Inspector's Report ACP-323024-25

Development	Proposed elevation of local tertiary road (L-52214)
Location	Cuan Na Loinge, Ceantar na nOileán, Conamara, Co. Galway
Local Authority	Galway County Council
Type of Application	Application for approval made under Section 177(AE) of the Planning and Development Act, 2000 (local authority development requiring appropriate assessment)
Prescribed Bodies	Inland Fisheries Ireland (IFI) Uisce Éireann (UE) Development Applications Unit (DAU)
Observer(s)	None.
Date of Site Inspection	27 th August 2025.
Inspector	Peadar McQuaid.

NOTES:

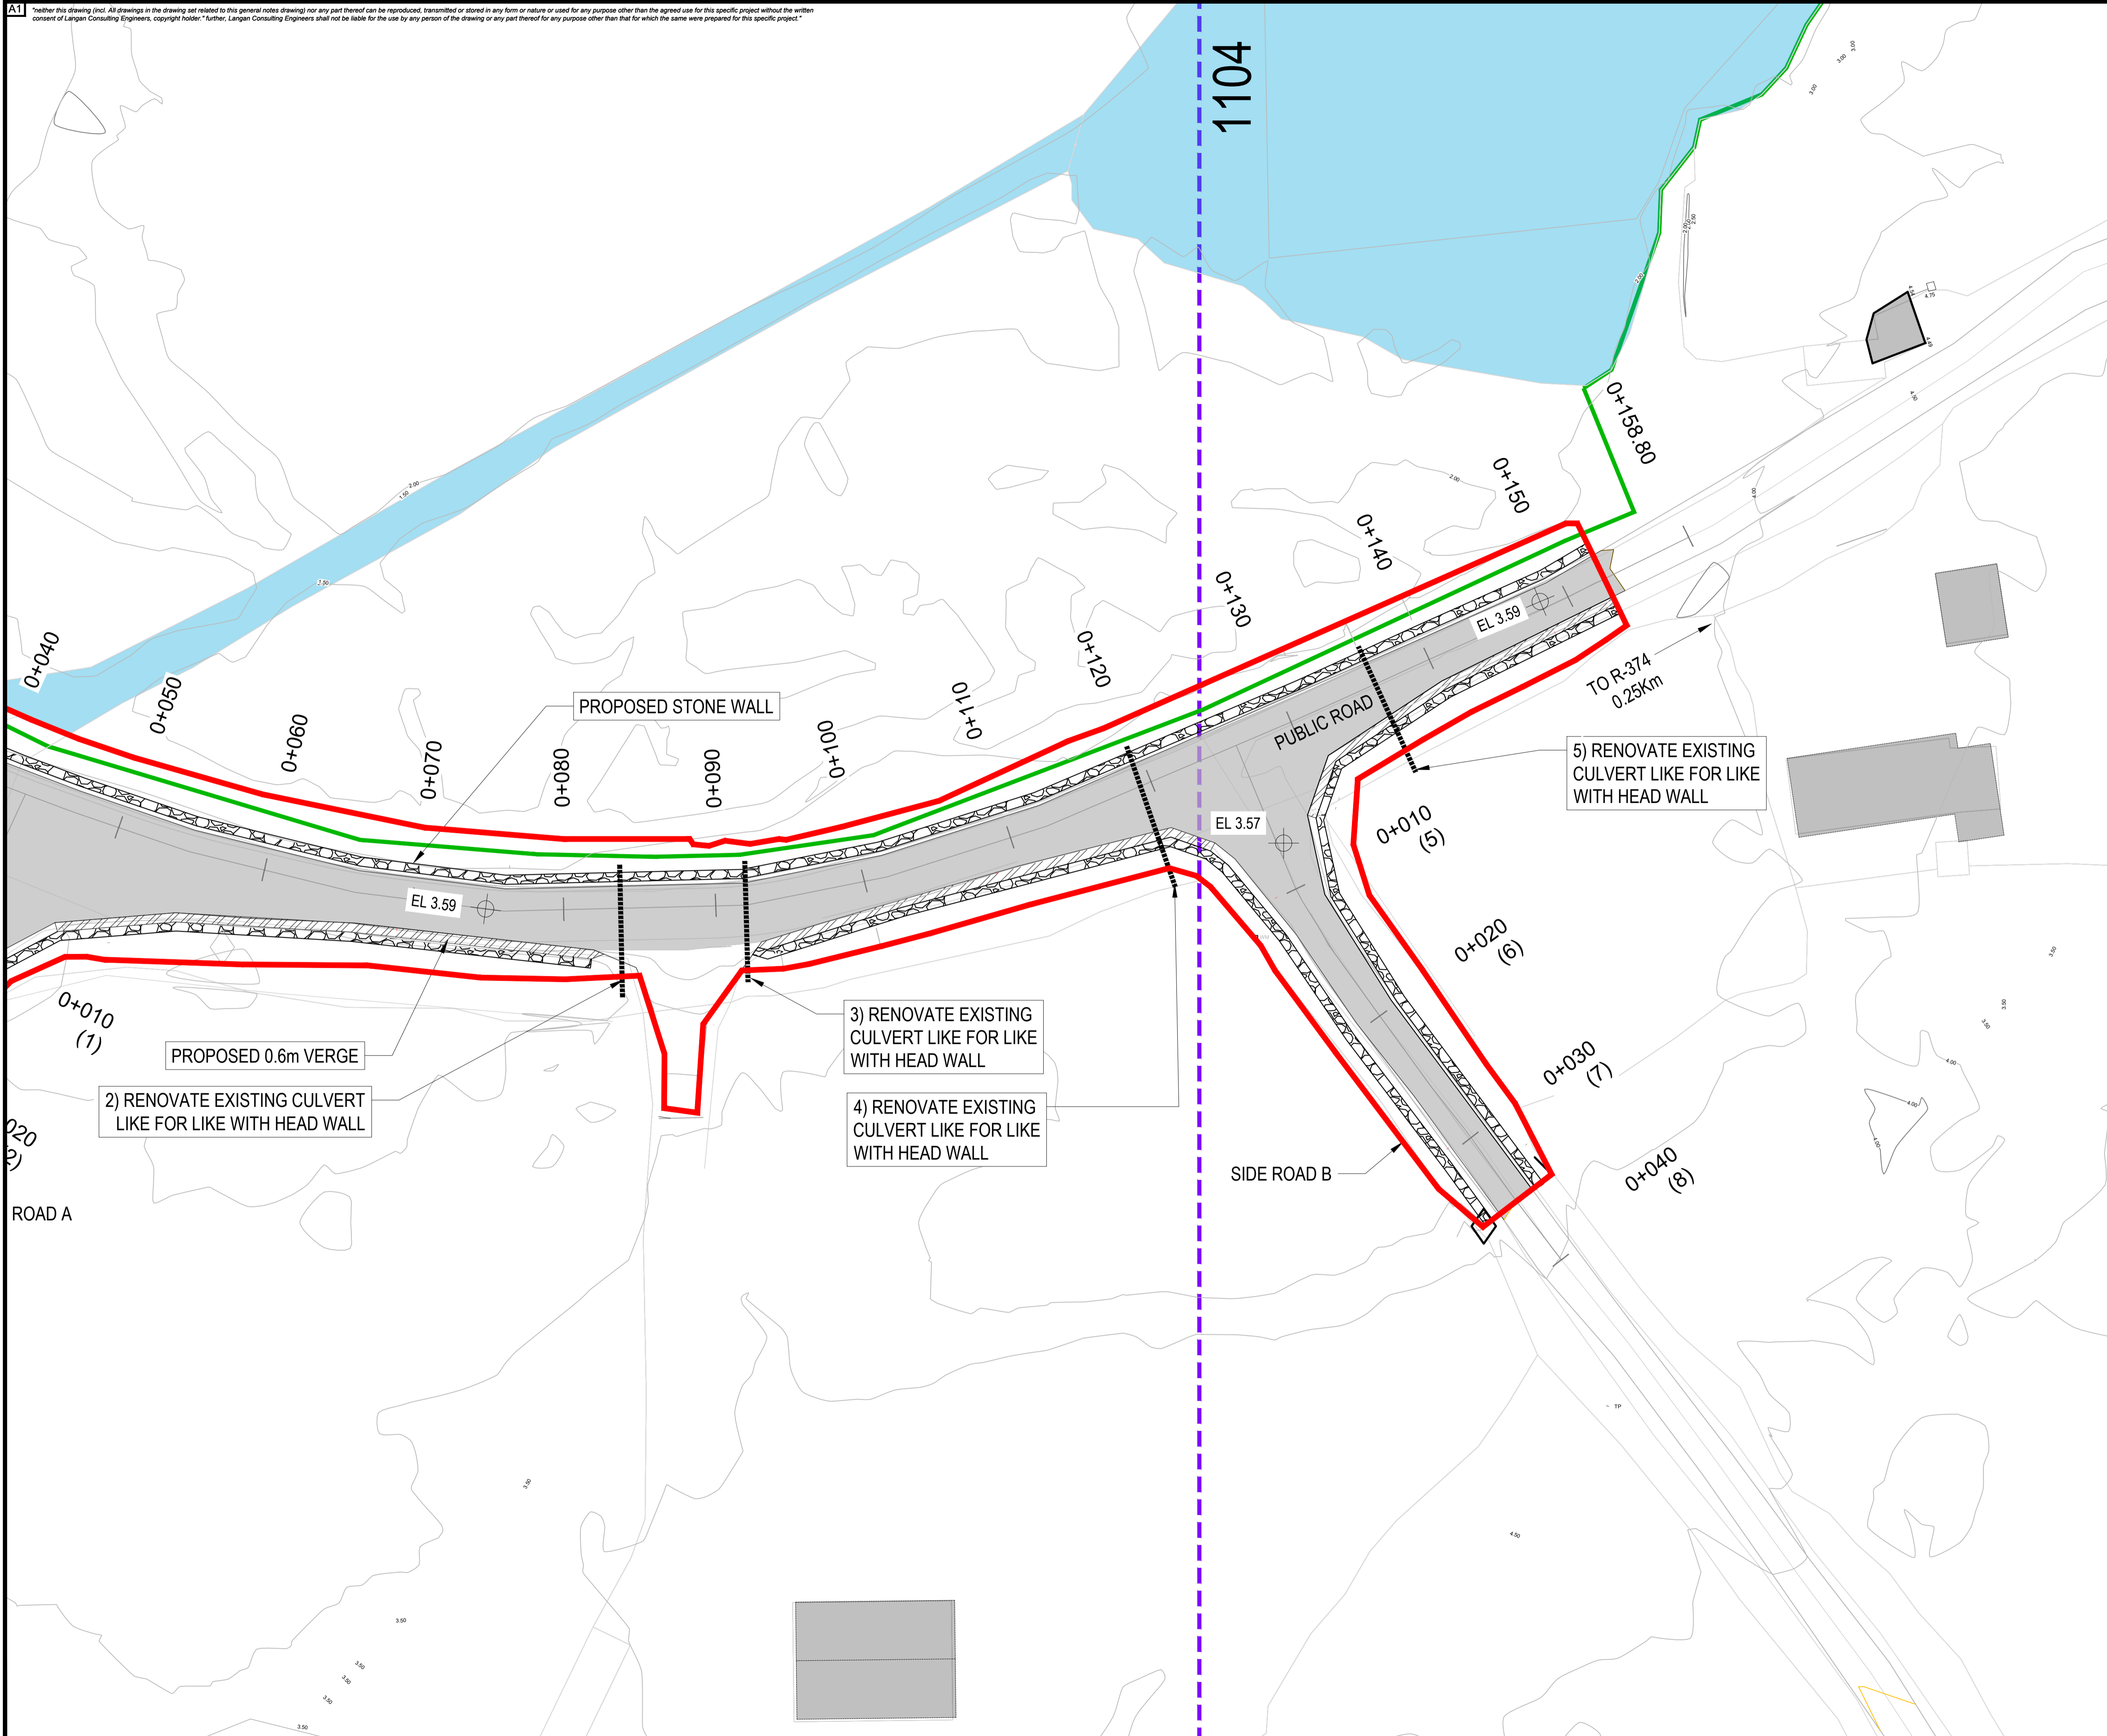
- The Department notes that the Natura Impact Statement (NIS) provided with the application does not identify that an area of the Annex I habitat Coastal Lagoon occurs immediately adjoining the proposed works (as outlined in Map 4 of NPWS, 20141). The NIS also states that there will be no direct loss of habitat within the SAC as a result of the proposed works, however, the cross-sectional diagram re-produced in the document '*Preferred scheme option report*' indicates that the rock armour, which will occur along the elevated road, will be significantly wider than the existing road.

- Consequently, there is some uncertainty as to whether the area of Coastal lagoons [1150], or Atlantic salt meadows (*Glauco-Puccinellietalia maritimae*)

[1330], will be subject to a loss of area as a result of the proposed development.

- The Department recommends that An Coimisiun is satisfied that they have sufficient information to determine that the proposed works, including the rock armour, do not extend into any areas that correspond to either the Annex I habitat Coastal lagoons [1150], or the Annex I habitat Atlantic salt meadows (*Glauco-Puccinellietalia maritima*) (f330). It is a Conservation Objective for both within the Kilkieran Bay and Islands SAC that their area be stable or increasing.

1. (a) Clarification on the presence and location of any QI habitat within the site boundary, having regard to best practice survey guidance and published research on Annex I marine and benthic/lacustrine habitats.
(b) A targeted habitat survey is required to be undertaken within the site boundary, areas proximate to and in the wider vicinity of the proposed works to inform the response to item 1 (a) above.

FI item 2 – The applicant has submitted revised drawings and cross section to show the boundary of the proposed works and the SAC. Drawing reference numbers: 24155-DG-1103, 24155-DG-1104, 24155-DG-1105 & 24155-DG-1202.

12.1.9. From a review of the revised drawings submitted (Drawing no's 1103 – 1105) and the Habitat Survey Report, I am generally satisfied that no non-EU designated Annex I habitats were identified within the proposed project footprint. Issues involving EU designated Annex I habitat are addressed in the appropriate assessment section of this report. I consider the existing/proposed road surface and associated hard standing is of negligible botanical interest.

Drawing file: Further Information Documents / Drg, 24155-DG-1202-PL01-Road Section.pdf

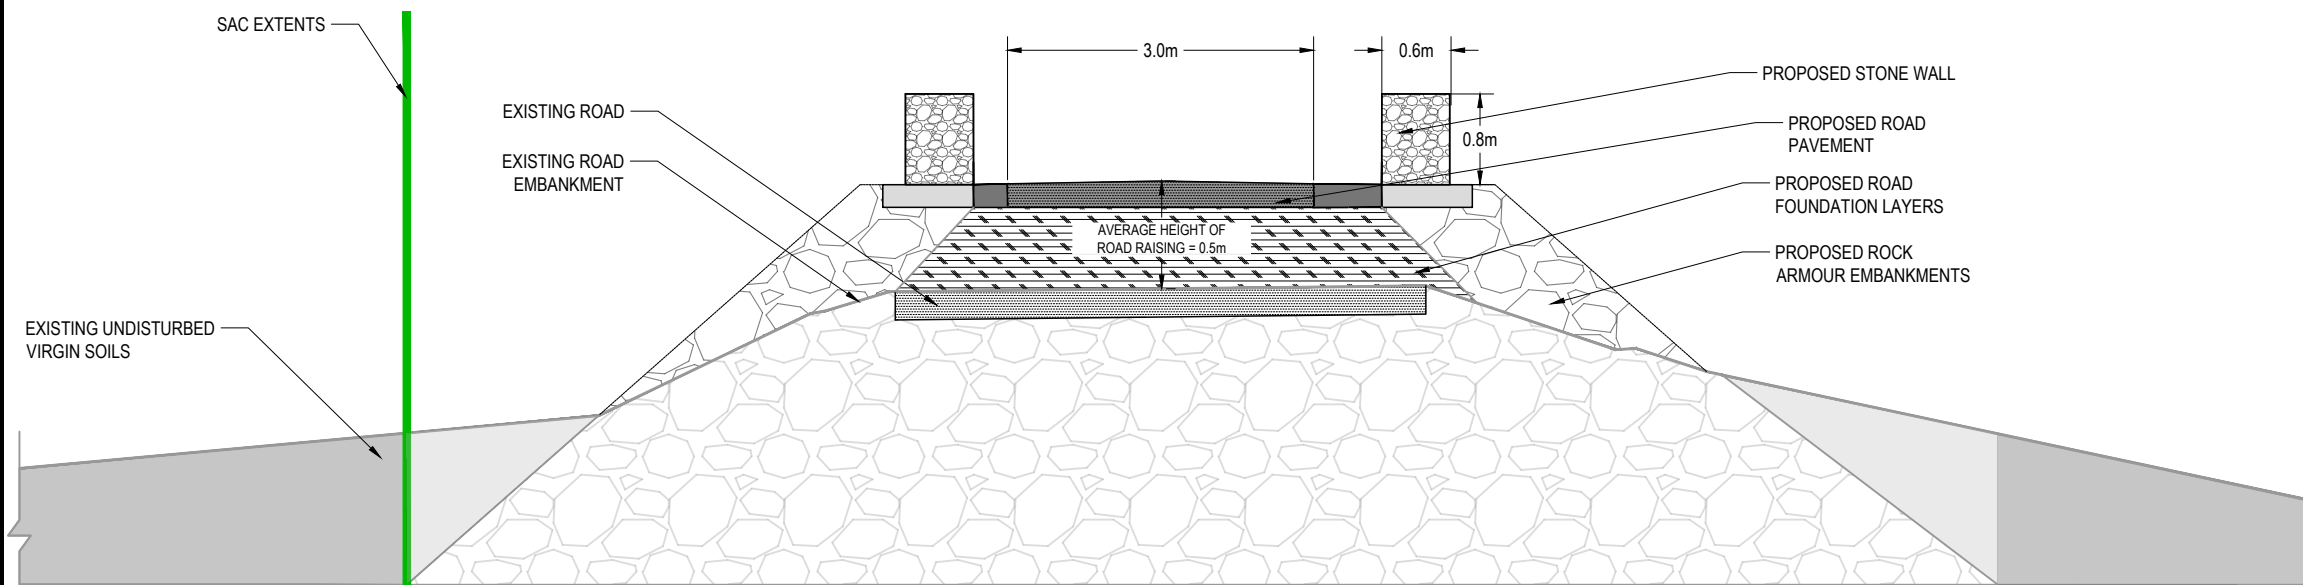
- i. The overlap between the application boundary, extent of the proposed works, the SAC boundary and Annex I habitat.
 - ii. Impact on Annex I habitat, as defined by its attributes and targets as detailed in the site-specific conservation objectives document for Kilkieran Bay and Islands SAC.
 - iii. Habitats providing a supporting function to the annex habitat.
 - iv. Habitats of biodiversity value beyond the Natura designation(s).
2. Detailed drawings (1:200 scale) showing the footprint of the proposed works, the SAC boundary and confirmed Annex I habitats/non-Annex I habitats within the application site boundary.
 3. Detail the area(s) of temporary and/or permanent habitat loss (if any) within Annex I habitat area.
 4. Justify, in terms of best available scientific information, why habitat loss (if any) will not result in adverse effects on site integrity of the SAC overall in
